Application Ref:	3/2025/0219				Ribble Valley Borough Council www.ribblevalley.gov.uk
Date Inspected:	13/05/25	Site Notice:	13/05/25		
Officer:	LW				
DELEGATED ITEM FILE REPORT:					APPROVAL

Development Description:	Proposed two-storey side extension to existing dwelling and internal alterations to enhance accessibility.
Site Address/Location:	White Carr Farm, Dilworth Bottoms, Ribchester, PR3 3ZB.

Drawing file: planx_downloads / 25_0291_Proposed_Plan_and_Elevations_Amended_200625.pdf

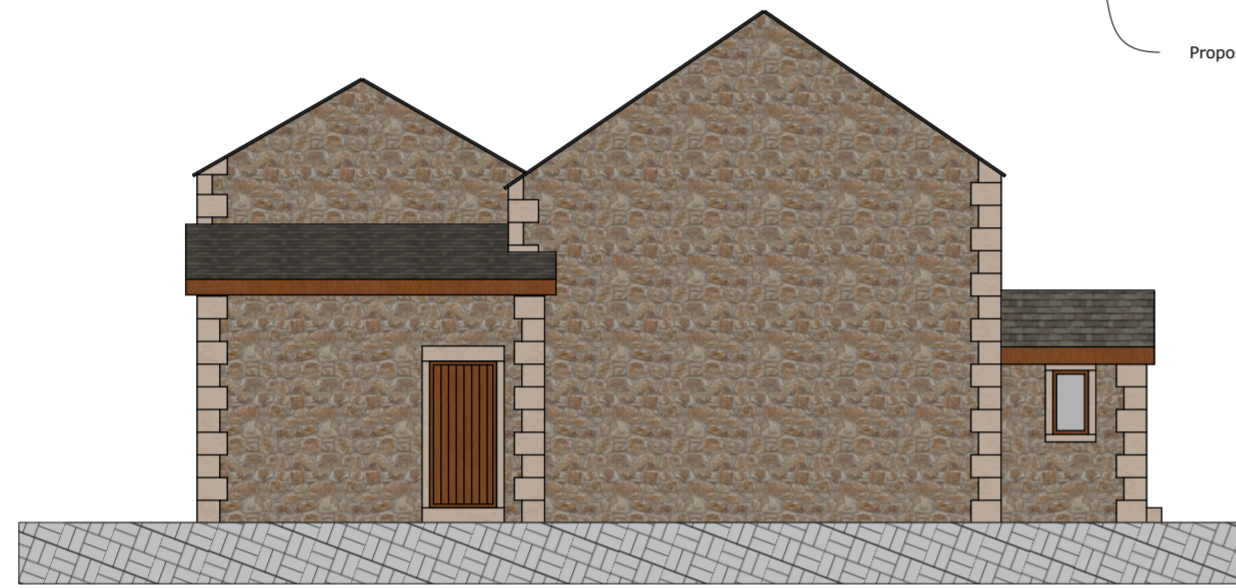
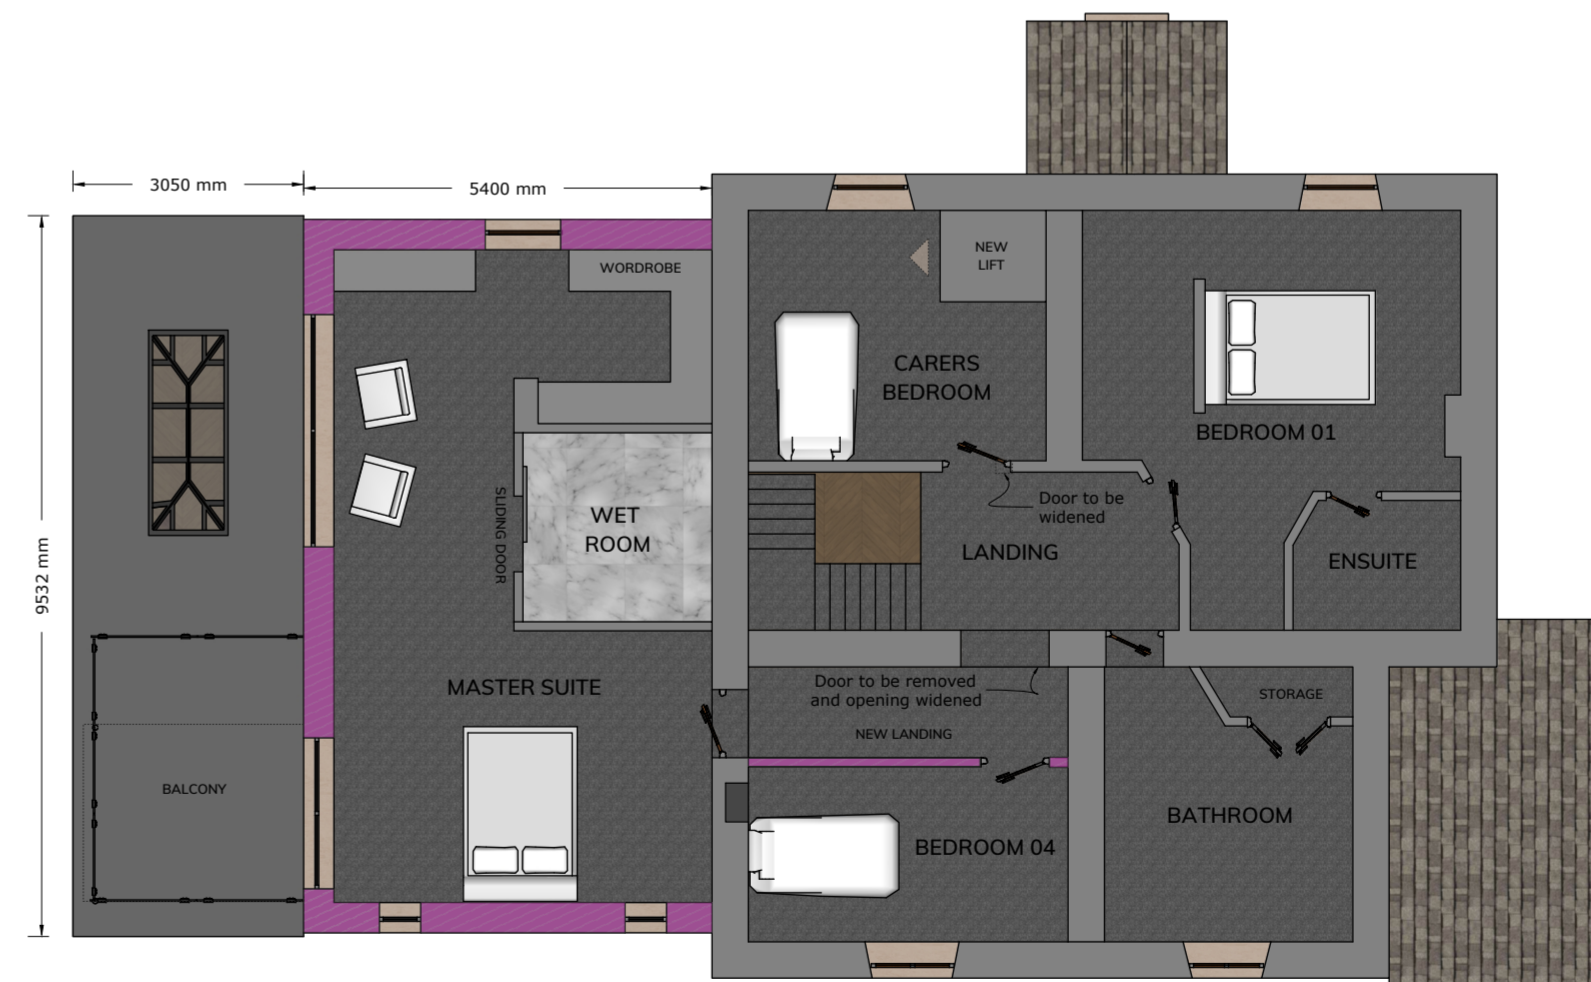
The external appearance of the proposed development has been amended since the initial submission of the application, including alterations to the front window configuration to ensure the proposal remains sympathetic to and reflective of the existing dwellinghouse. The original proposal also comprised a slate pitched roof canopy over the proposed balcony and timber effect composite panelling to the front elevation of the single storey element. However, the proposed canopy was considered overtly bulky and visually prominent, whilst the proposed panelling was considered out of keeping with the traditional stone-built principal elevation of the application dwelling.

Following discussions with the agent, these elements of the proposal have been revised, with the development now proposed to incorporate a glass lean-to canopy over the balcony and random stone to the front elevation of the single storey extension. Whilst the use of timber panelling to the side and rear of the single storey extension, extensive glazing to the side and addition of a glass canopy and balustrade to the balcony would all result in contemporary additions to the existing stone and slate built dwellinghouse, the above amendments are considered, on balance, to address the aforementioned concerns whilst still ensuring that the development meets the identified needs of the applicant. As such, it is not considered that amended proposal would result in any significant detrimental harm upon the existing visual amenities of the immediate or wider locality that would warrant the refusal of this application.
